Subject: R/176/21/PL

Thank you for consulting Environmental Health on the above application. I have considered the above application and can advise that we require additional information to assess the proposal's environmental impact on neighbouring residents fully.

Proposed Floor Plan

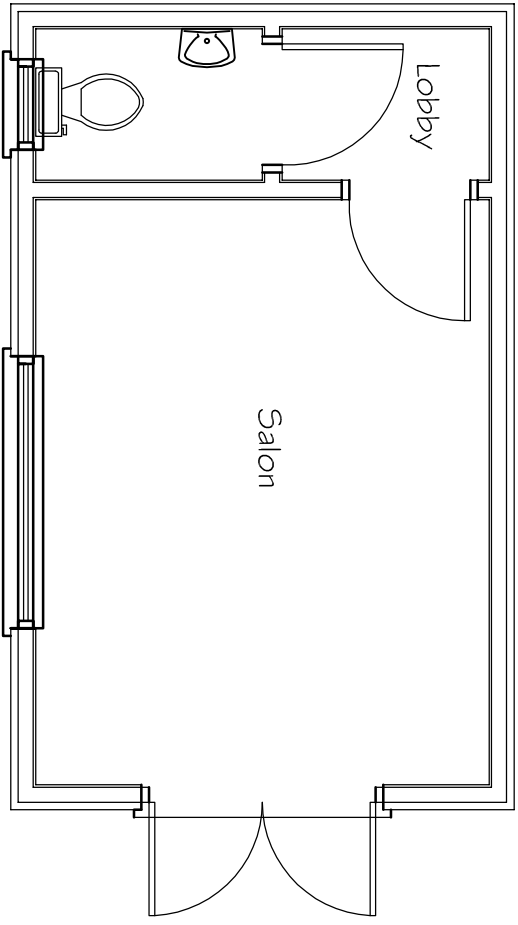
The outbuilding adjoins a few residential gardens, and such a scheme could harm adjoining properties because of noise emanating from the outbuilding. We require details of any plant or equipment proposed, and the number of clients expected. The applicant needs to confirm proposed trading hours, including noise sources and any mitigation.
